From: Grant, David
Sent: 09 September 2020 20:49
To: _planningadvice
Subject: FW: H17-0622-20 Land adjacent 23 Stockhouse Lane

CHRIS LILLEY
ARCHITECTURAL SERVICES

Project:	New Dwelling	Date:	July 2020
Address:	Stockhouse Lane, Surfleet, Spalding	Scale:	1:200 on A3
Client:	Mrs T Brand	Job No:	20073
Drawing Title:	Proposed Site Plan	Dwg No:	02 A

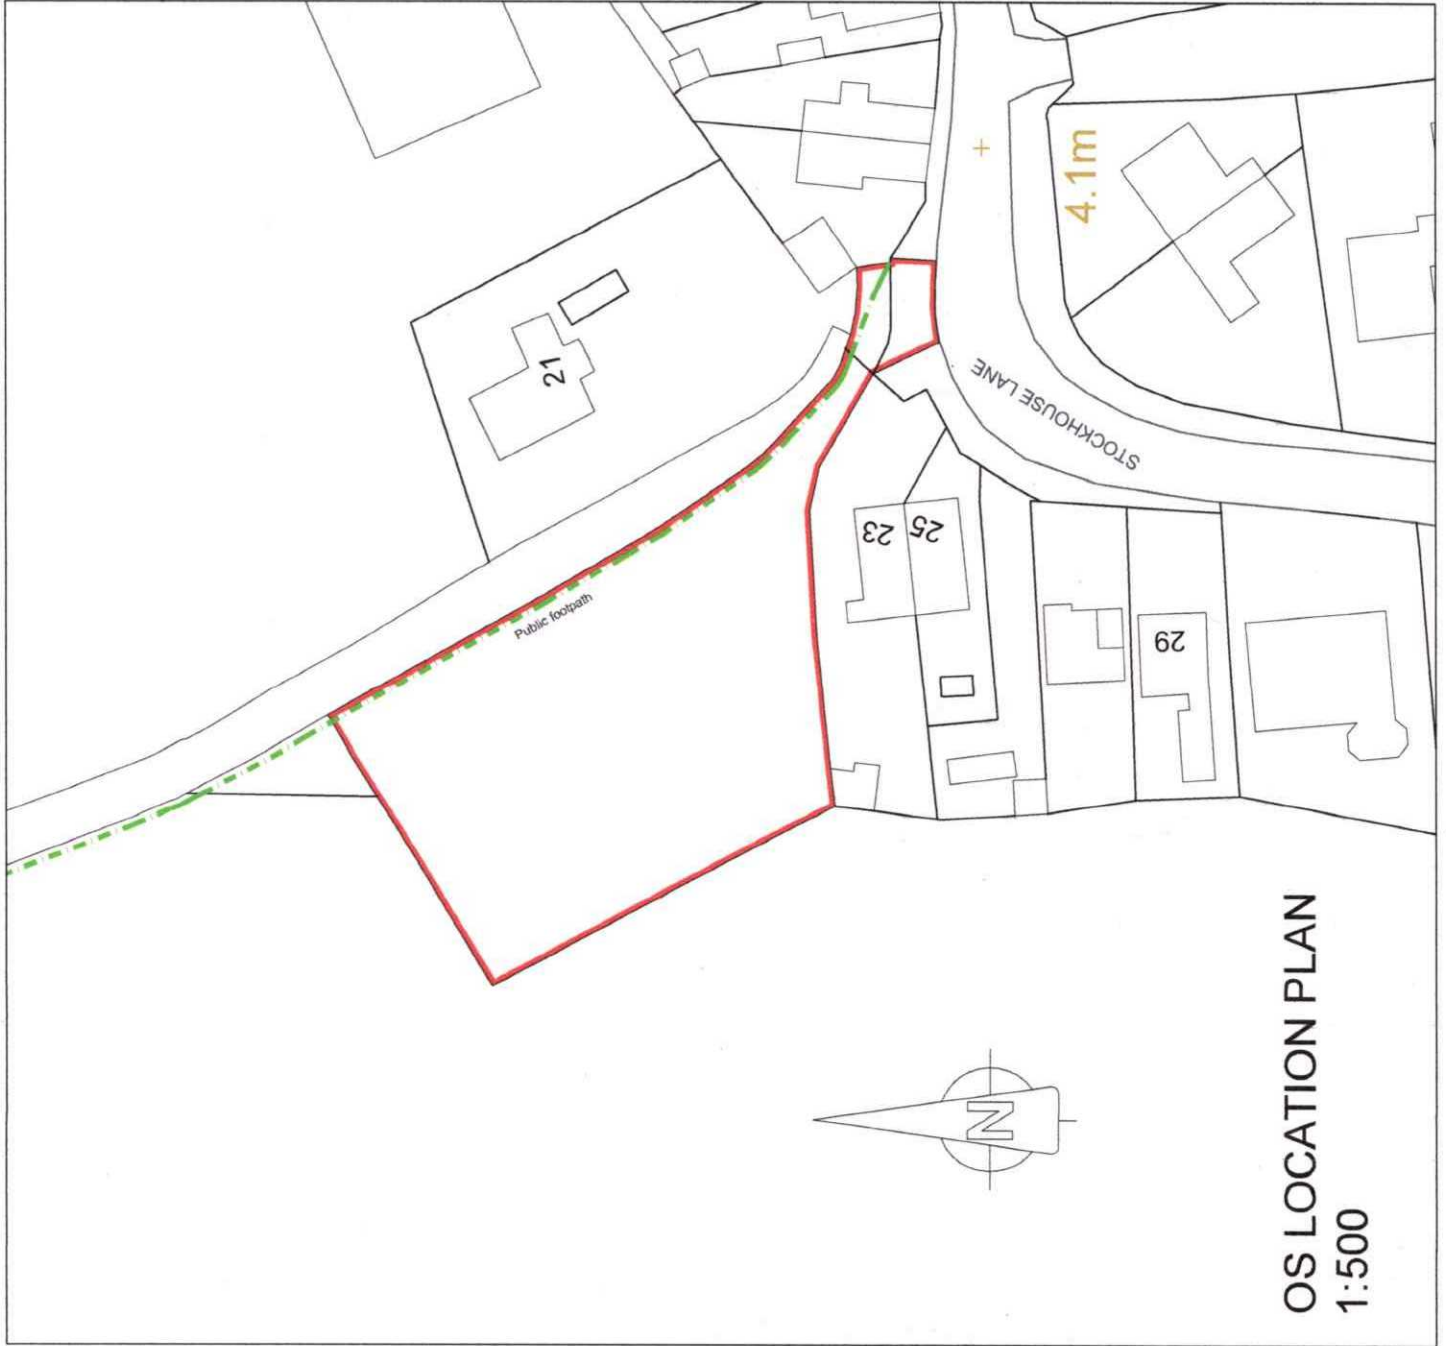
1. Design is out of keeping with character of surrounding area.
2. Overlooking
3. Overshadowing
4. Overbearing
5. Loss of view
6. Parking provision and disturbance during construction.

2. Overlooking - Again I understand from the previous design approved under reserved matters that the residents had concerns regarding overlooking, as the main bulk of the habitable rooms at first floor level faced directly into the garden area of the property to the south of the site. Although the distance between first floor windows to boundary was more than acceptable, myself and the applicant wanted to ensure there was no overlooking of any of the neighbours. This is also reflected in the rectangular shape of the design that positions the building so that there is no overlooking of any neighbours properties or gardens.

3. Overshadowing - The building is situated due north of any neighbours properties and therefore a shadow will never be cast over the neighbours property or gardens.

5. Loss of view - The site is surrounded by open fields on the west and north elevation. The views from the neighbouring property to the south of the site is due west and east. The proposal being located due north of this site and screened by mature trees doesn't affect the direct view that the neighbour already has at present. The east boundary of the site is screened by mature trees, the neighbour to the east of the site's views are north and south. Again the proposal being located due west of this site and screened by mature trees doesn't affect the direct view that the neighbour already has at present.

6. Parking provision and disturbance during construction - The site has a long driveway from the main highway that ends in a substantial open courtyard and is served by a double garage. The parking provisions are in excess of the Local Authorities parking standards, which means there is no possibility that parking will occur on the public highway. The long driveway also ensures that in the event of deliveries, the driver will drive up the drive and turn around in the courtyard, as opposed to parking on the public highway and walking to the property. The substantial open courtyard also serves as a material store and parking area for construction workers during the construction process, and for a property of this size, with the number of workers on site at any given time is in excess of the space typically allocated for construction workers needs.
